February 18, 2020

Re: Review of Grandwood Development

<b>GRANDWOOD RANCH</b>			
<b>PRELIMINARY PLAN - PCD FILE NO SP195</b>			
<b>PLAN SHEET</b>			
DESIGNED BY: CAP	SCALE: HORIZ 1"=100'	DATE ISSUED: APRIL 2020	DRAWING No. PP 02
DRAWN BY: CAP	VERT.	SHEET 4 OF 6	
CHECKED BY: JA

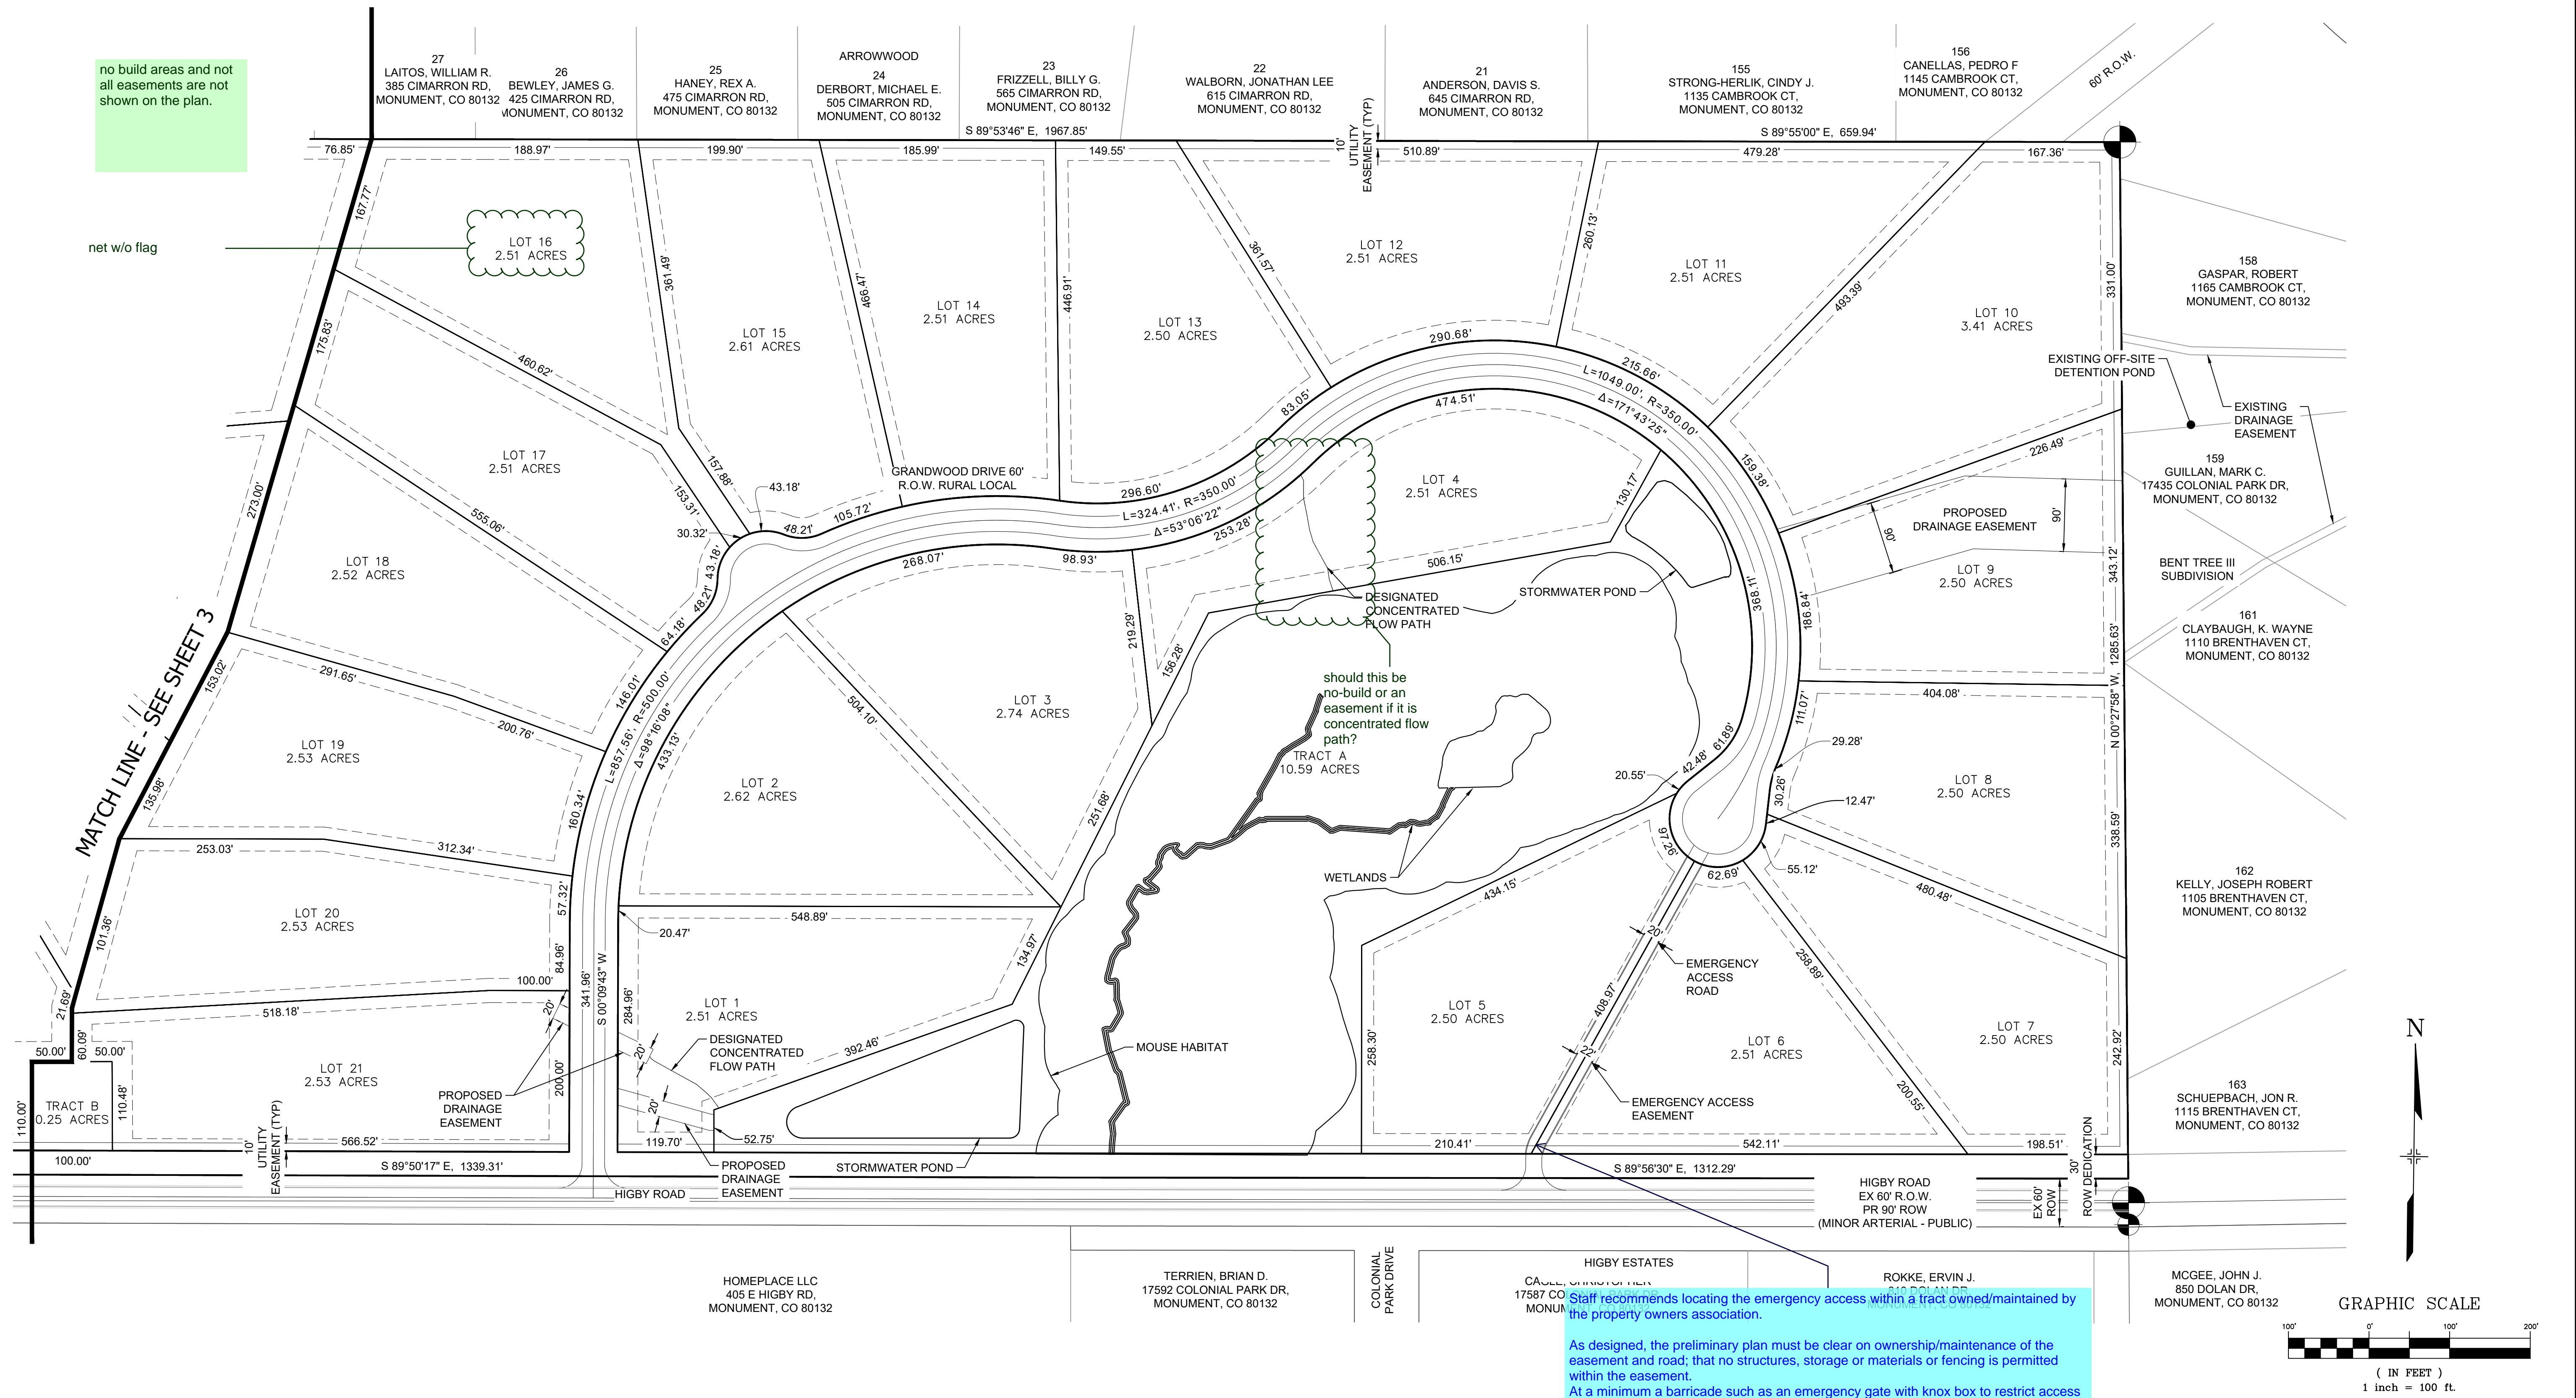
1. Comment No. 1 stating "Developer should modify eastern roadway to align with Colonial Park Road rather than the west side of the cul-de-sac as shown on the plan. (See attached rough drawing.) This effectively reverses which end connects to Higby Road and which one terminates at a cul-de-sac." shall be deleted and replaced with Developer shall work with the developer of Home Place Rand on the south side of Higby Road to align the centerline of Grandwood Drive with the centerline of the existing road/driveway on the south side of Higby Road which is planned to remain.
